DECISION DELEGATED TO DEVELOPMENT MANAGER

Application No:	H20-0936-20	Applicant:	Mr D Sullivan
Proposal:	Proposed Dwelling		
Location:	Adj. 28 Jarvis Gate Sutton St James Spalding		
Terminal Date:	1st March 2021

SATE PLAM

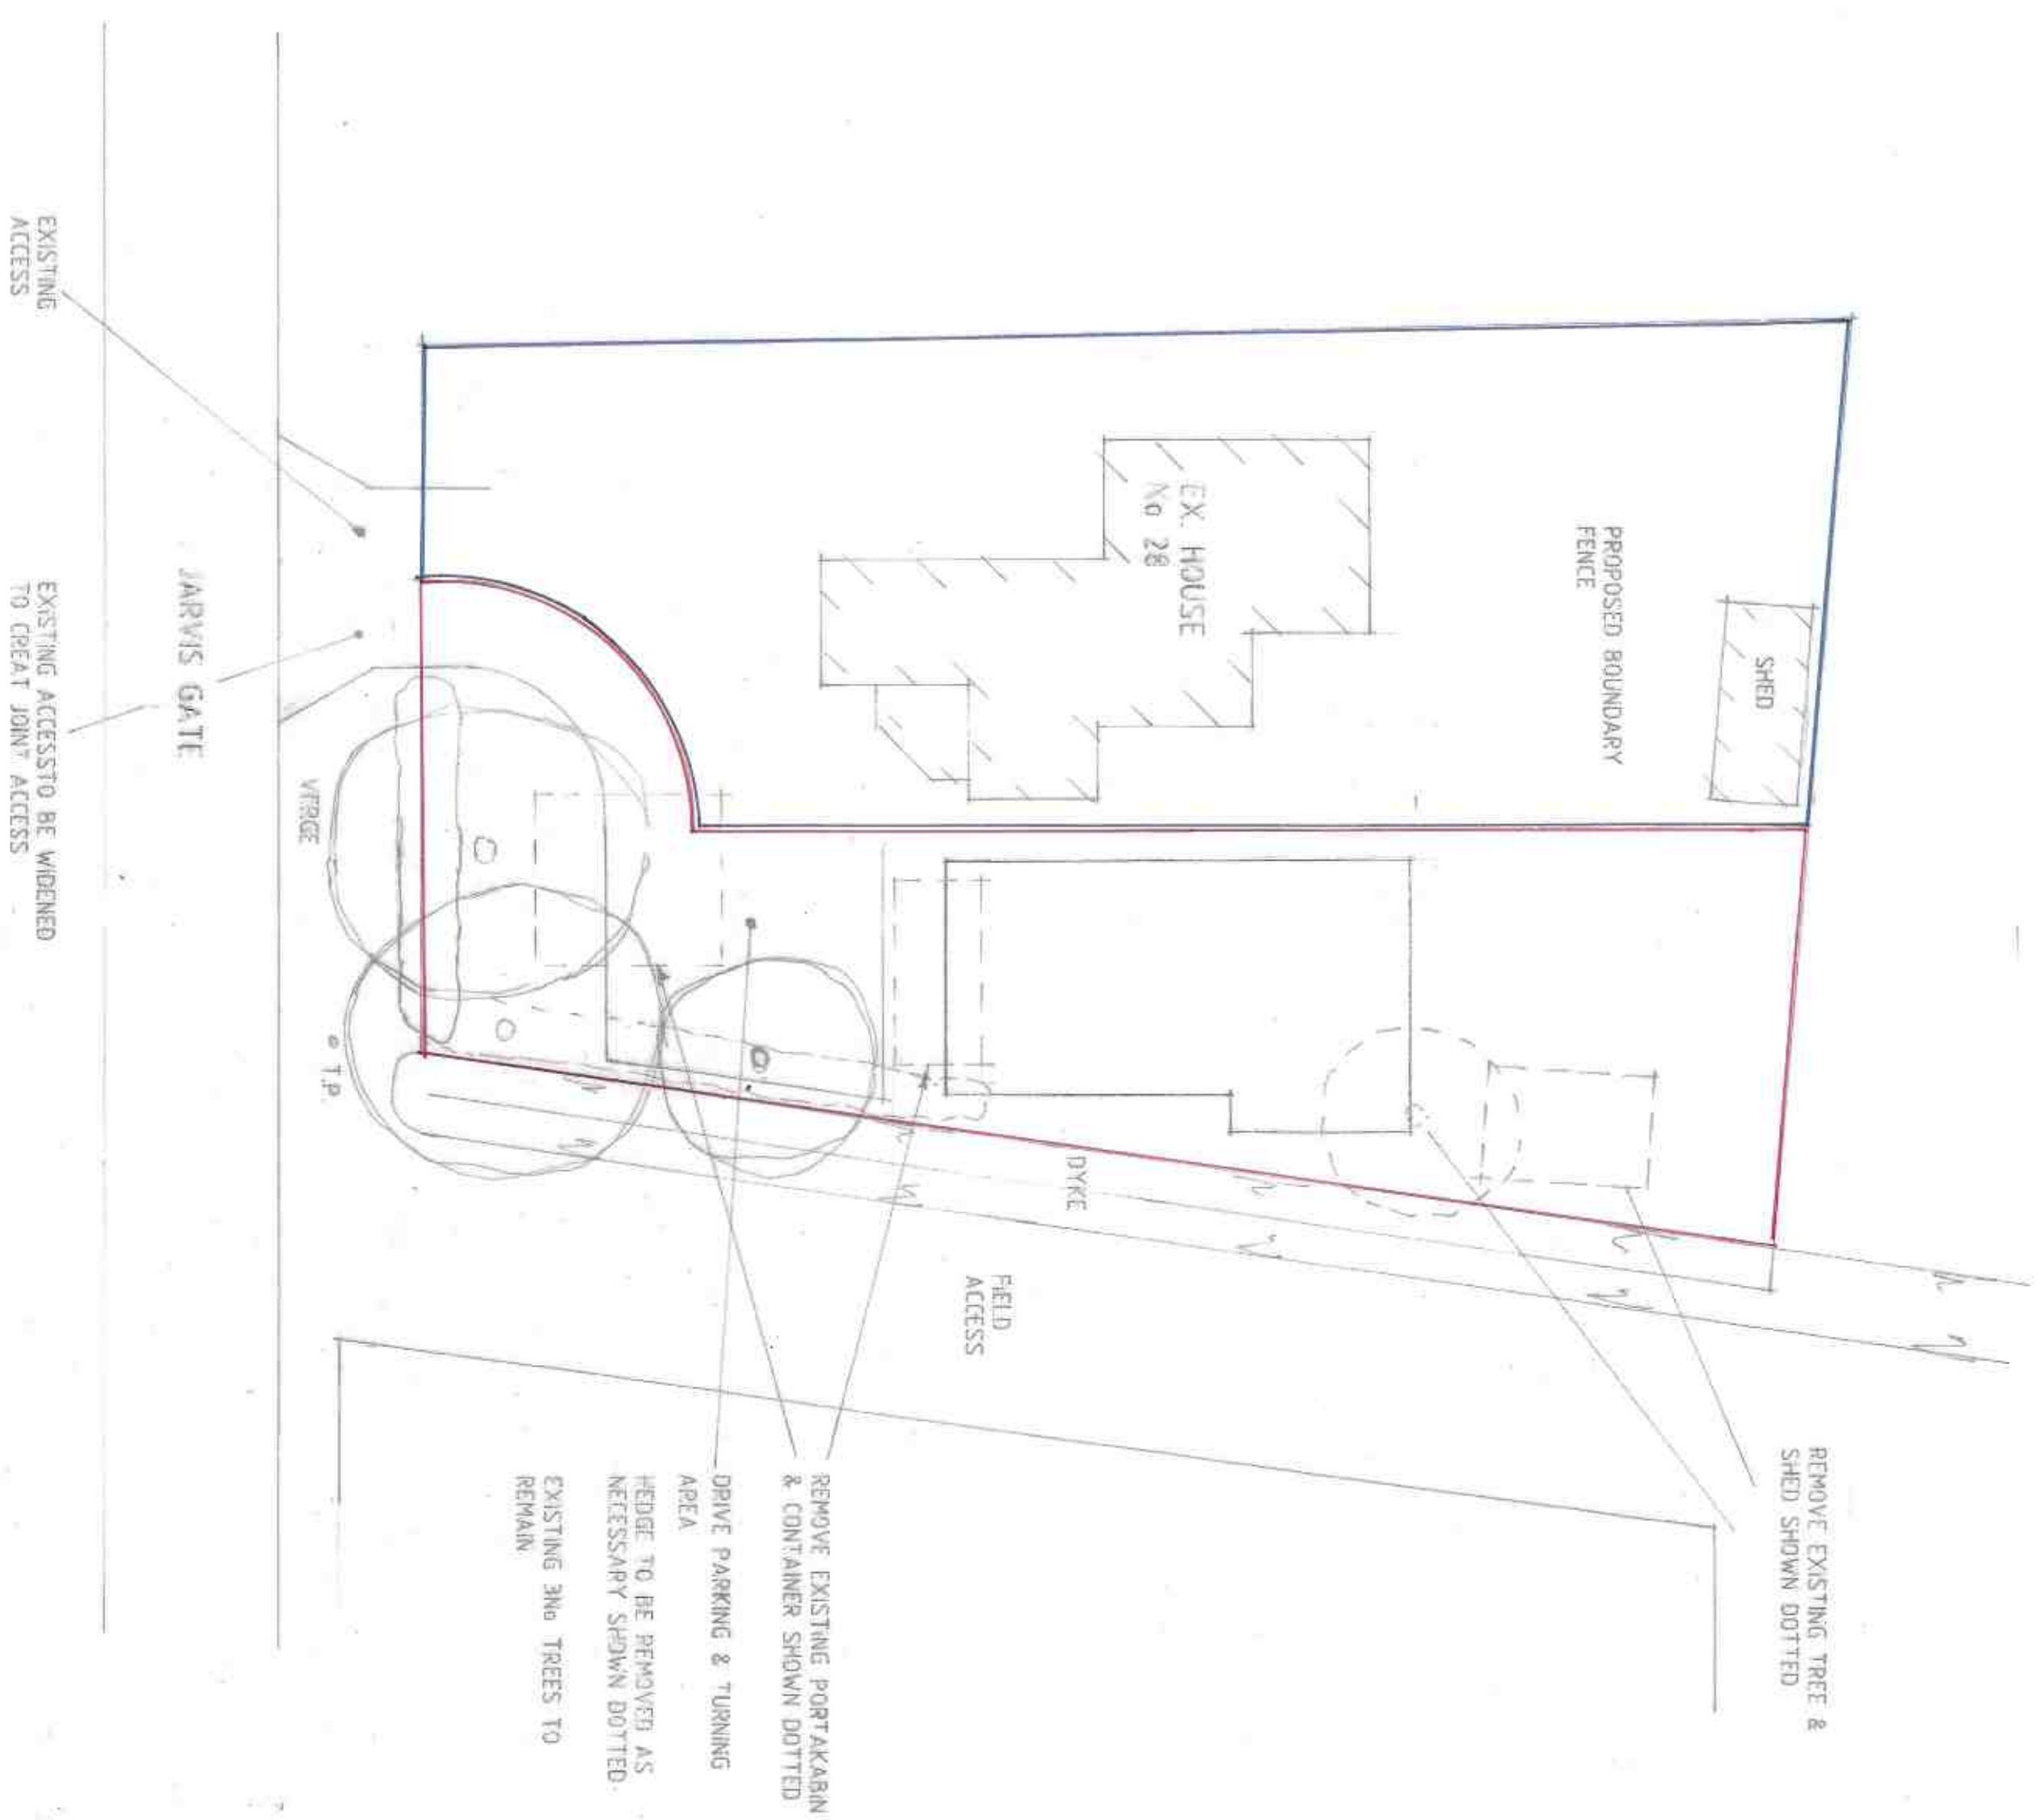
Three mature preserved trees the subject of Sutton St James TPO No. 7, 2006 presently exist along/close to the site's frontage. The Tree and Nature Conservation Officer has raised concerns over the vehicular access in particular passing between them. Given these concerns the applicant has re-positioned the access further to the north so that it is shared with the existing property. An existing container and portacabin underneath/close to them would also be removed. It is now considered that a dwelling could be accommodated without prejudicing or materially harming the existing frontage trees, subject to mitigating conditions.
